**Proposed Development  
SOPA Site,  
Wentworth Point.**

**Transport Impact Study  
Addendum**

September 2014

Job title:	SOPA Site Transport	Job number
		2013119

<u>NOTE</u> DESIGN VEHICLE – 14.5m LONG RIGID BUS (AUSTROADS 2013). DESIGN SPEED – 15kM/h. CENTRE RADIUS – 14m.

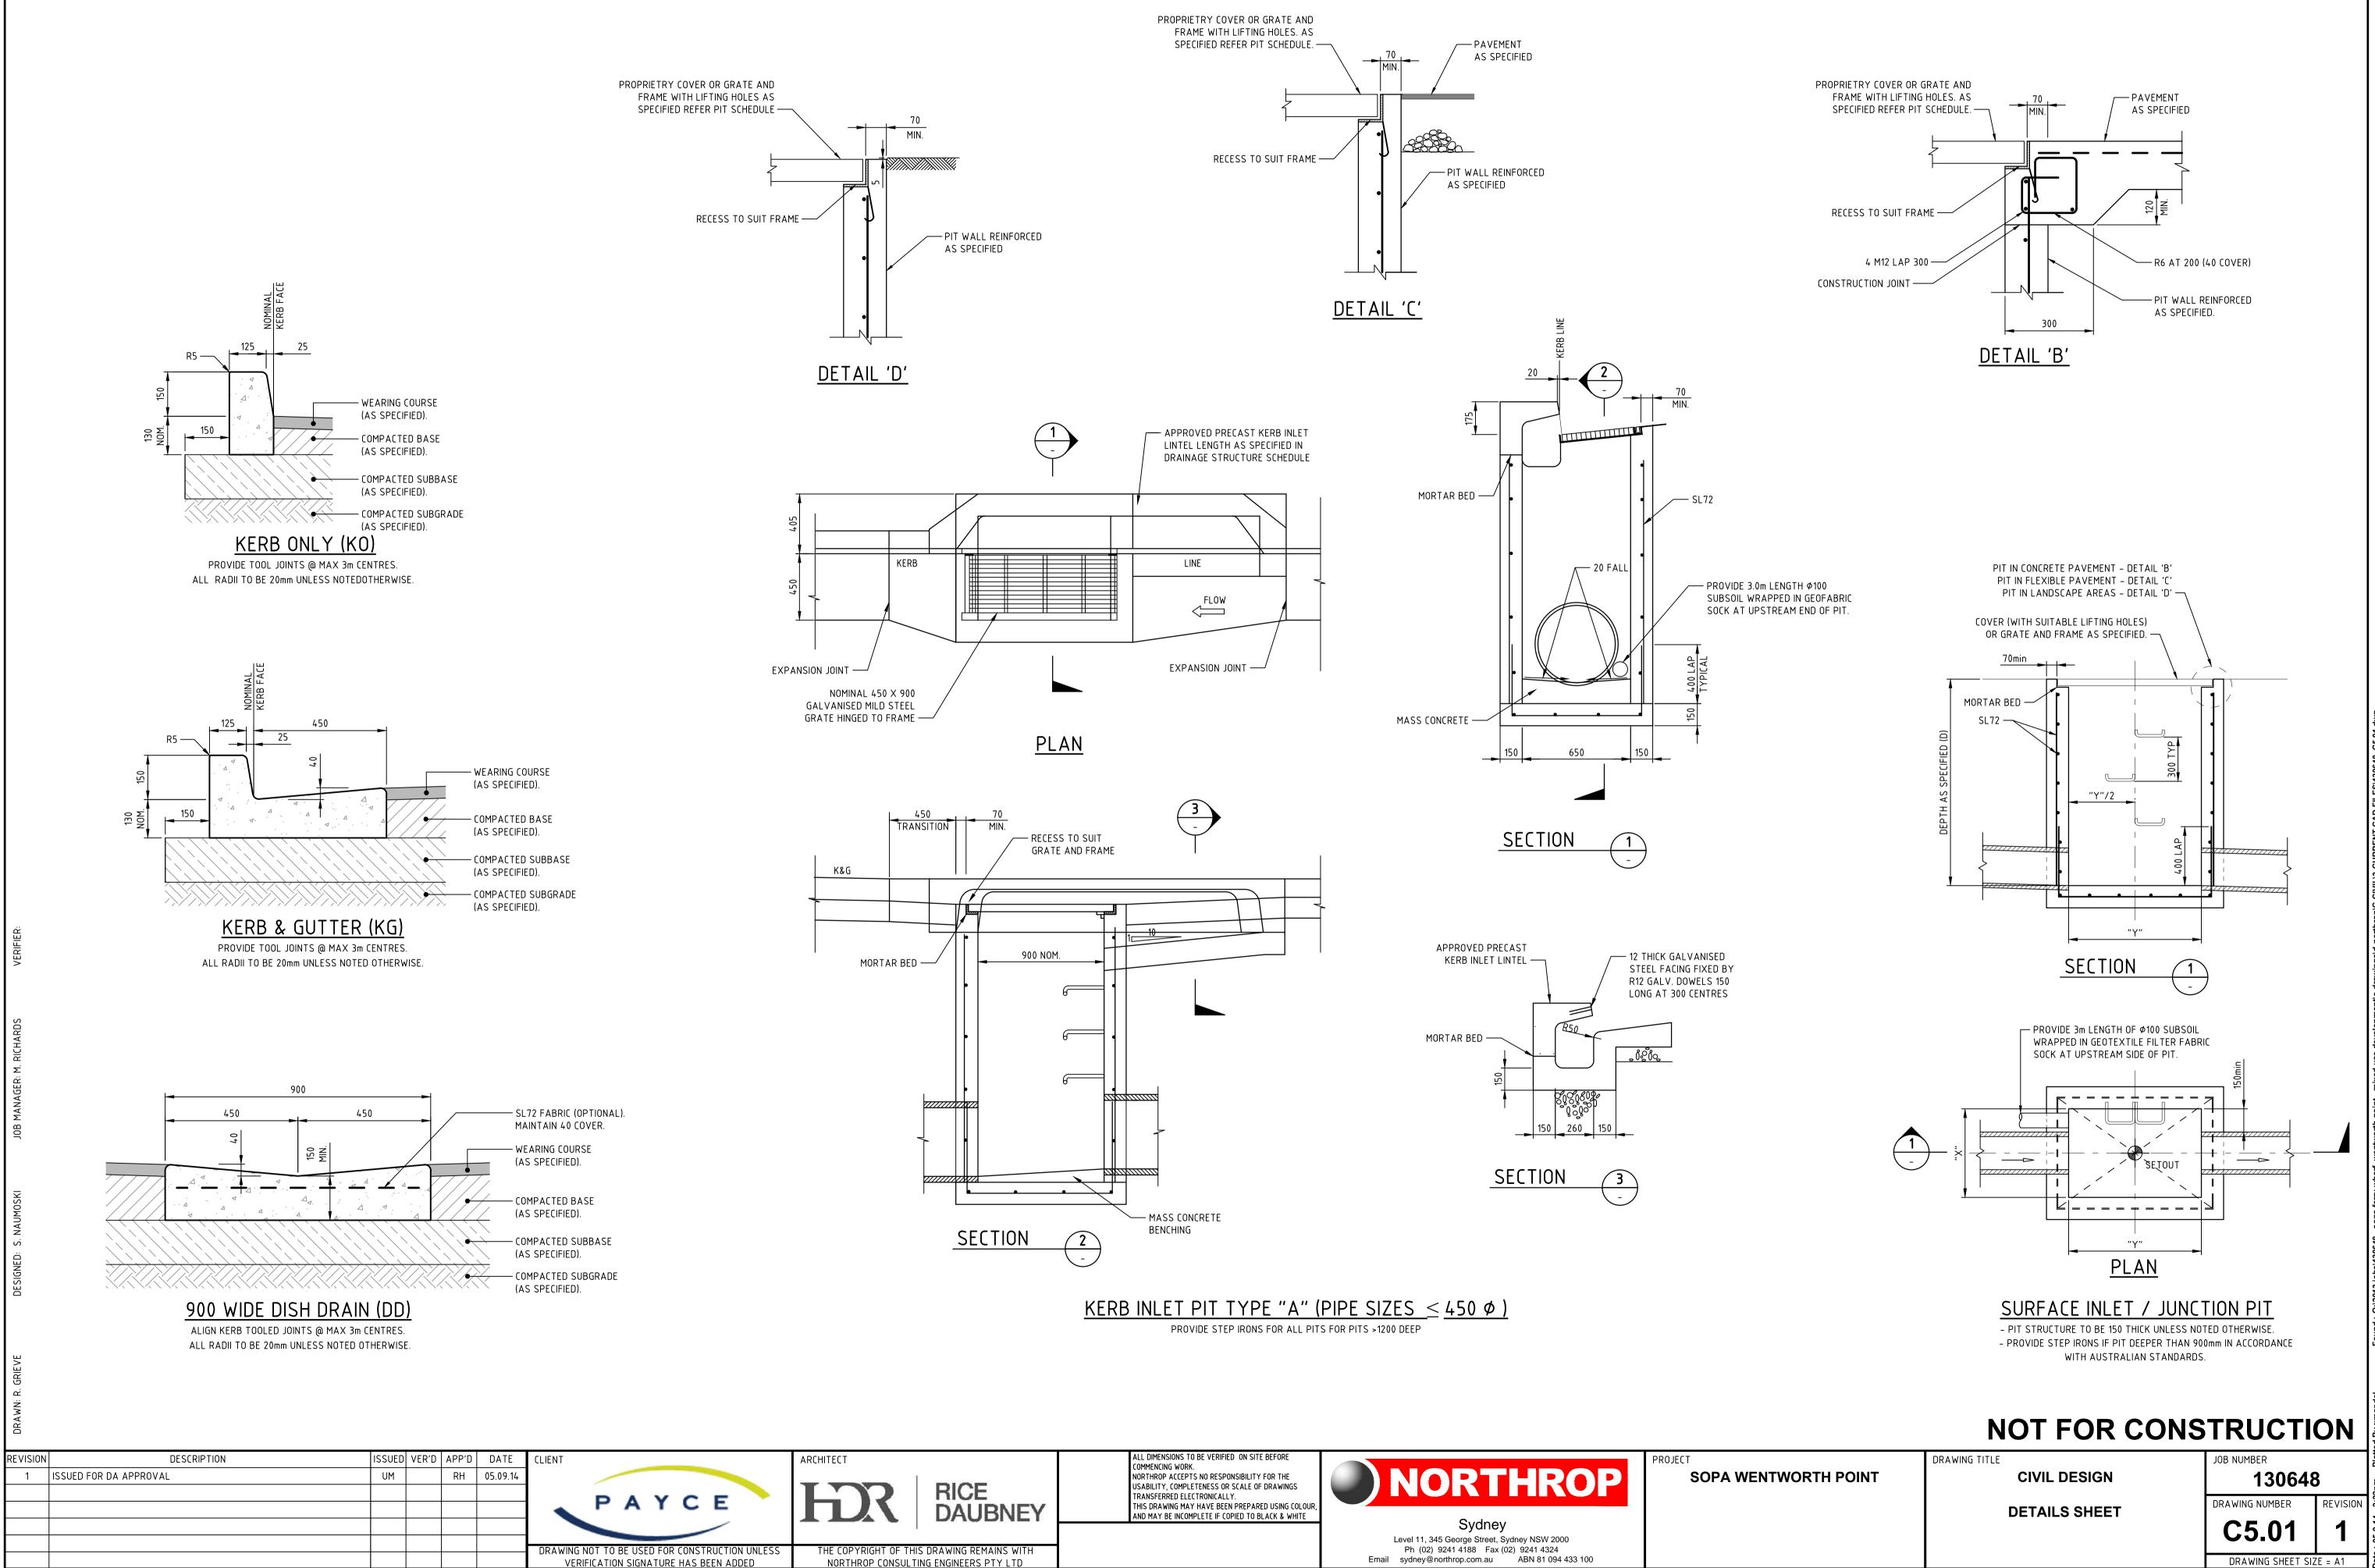
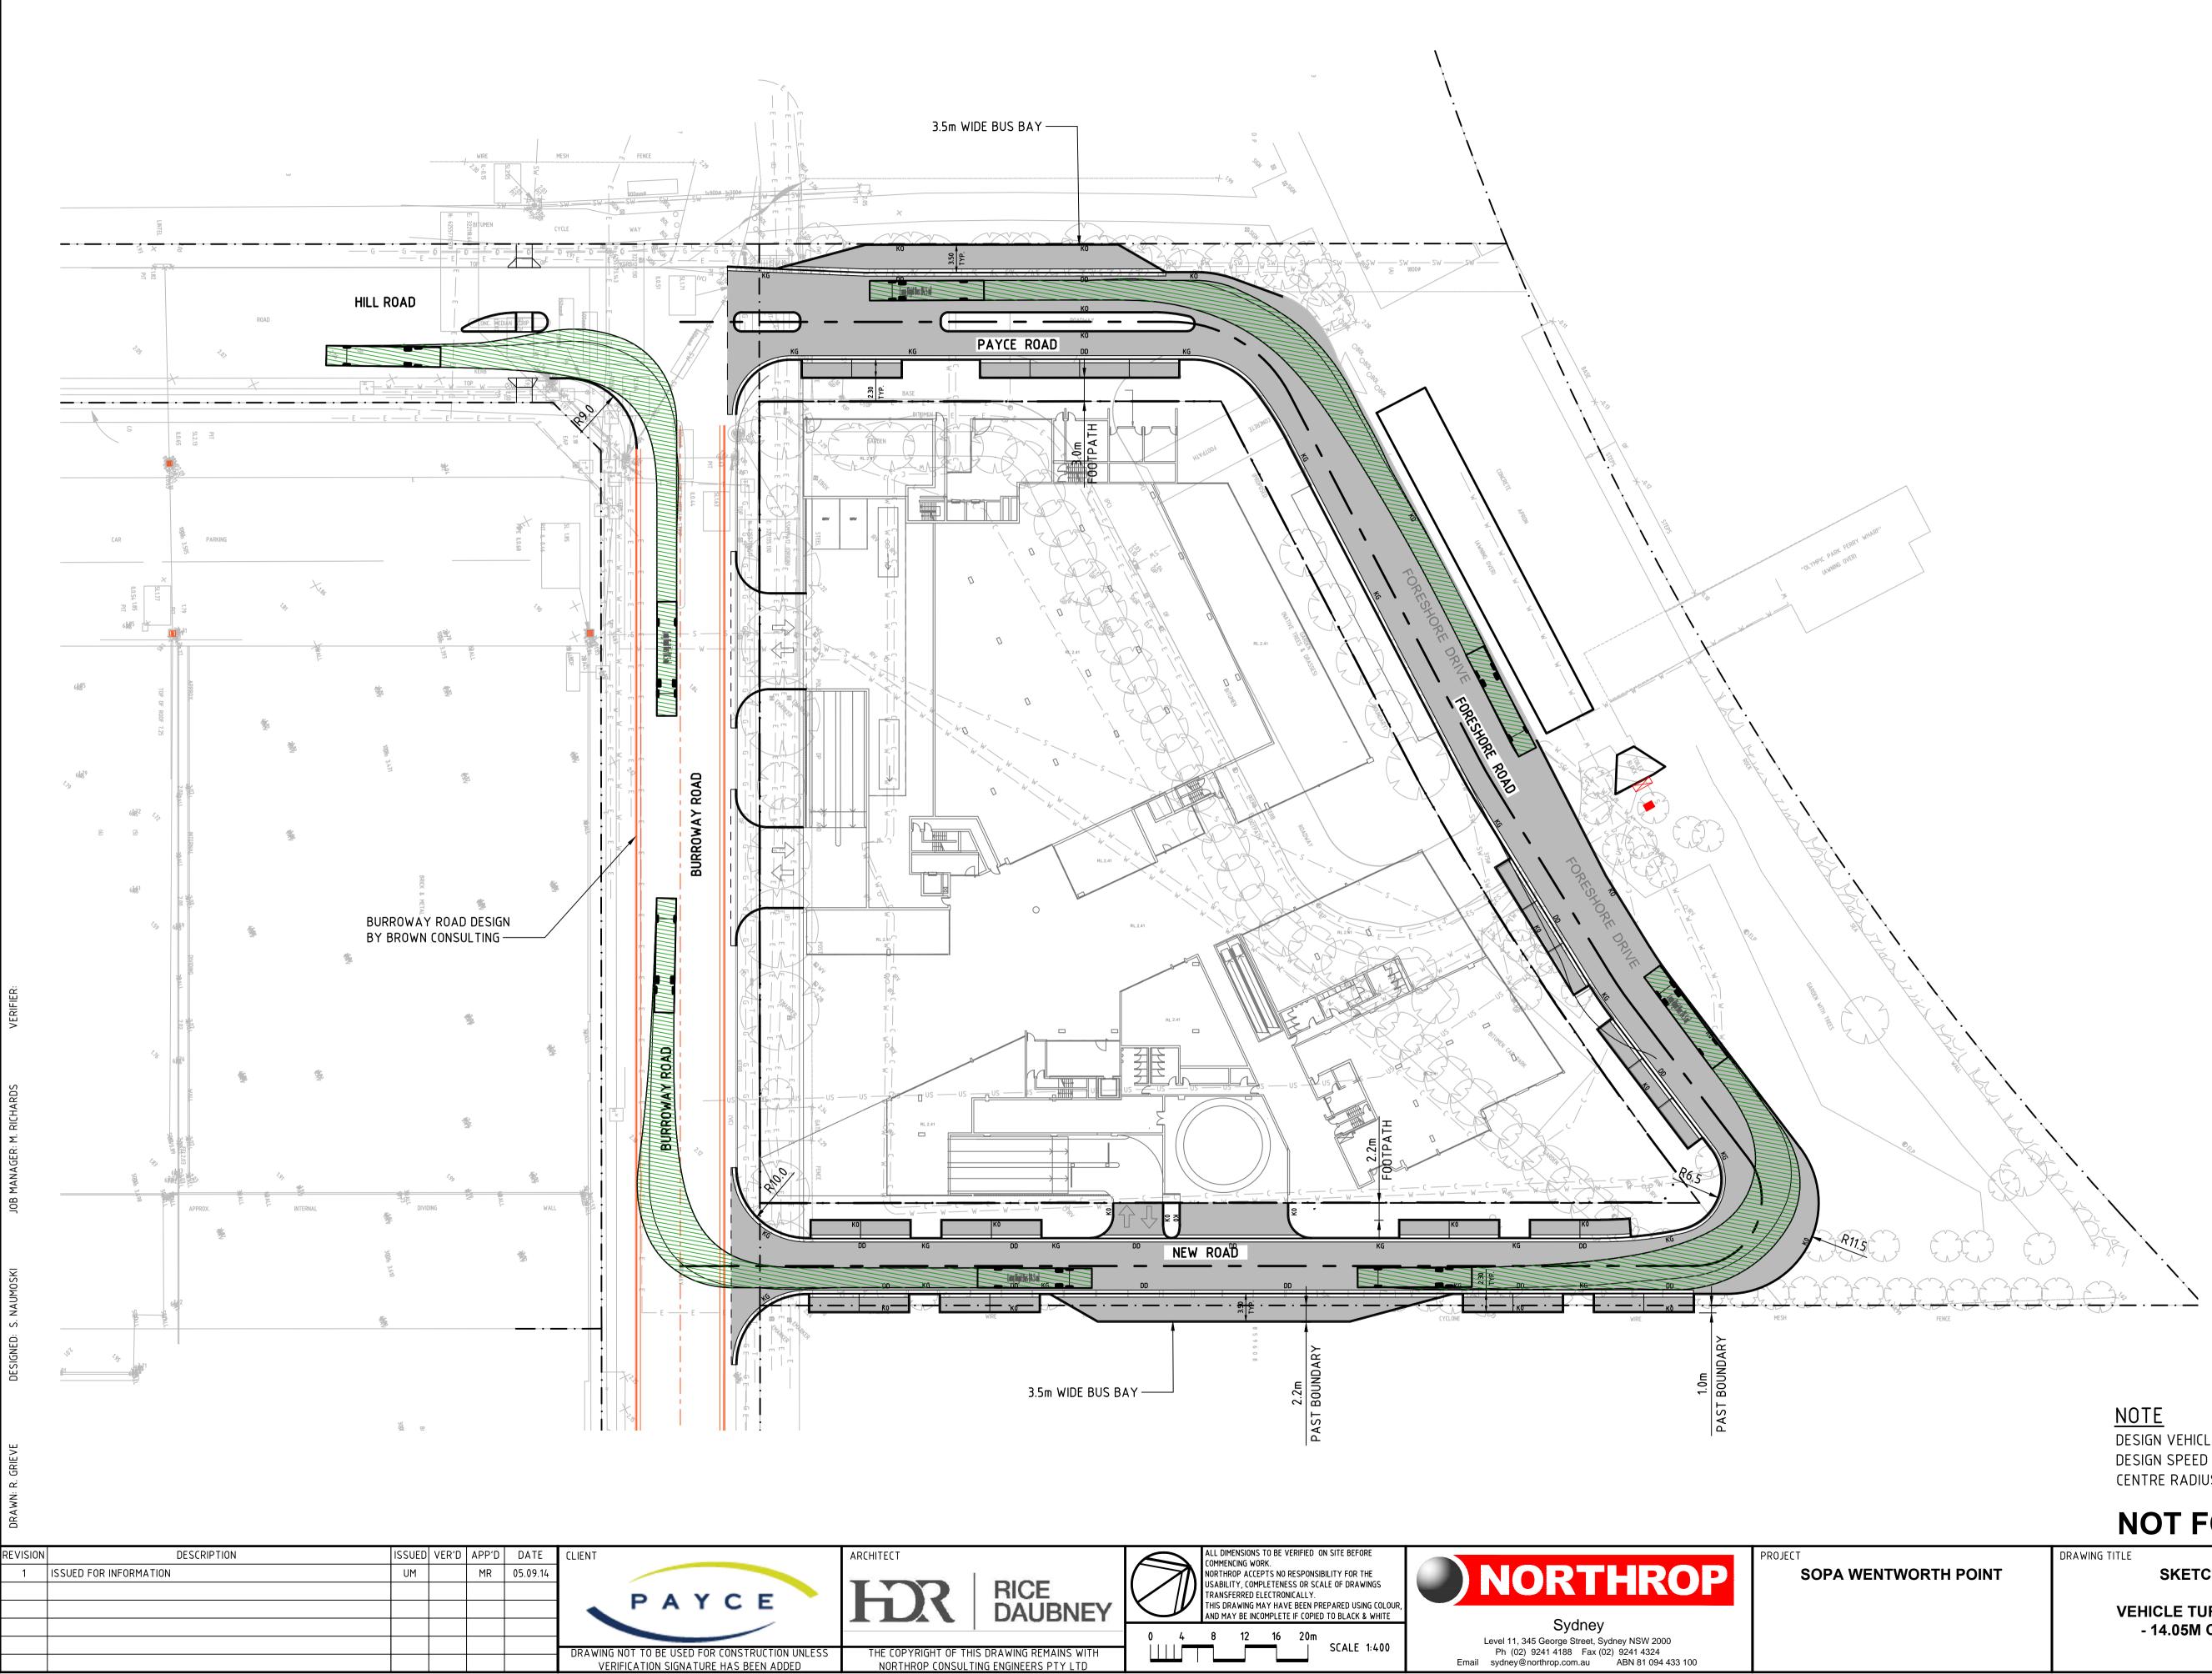
## **2.4      19. The road network must be designed to be accessed by a 14.5m coach for occasional services. Details should be incorporated in the design.**

Agreed. The Civil Engineering Drawings (SK5.01) demonstrate that the currently proposed road network is designed to be accessed by a 14.5m coach for occasional service.
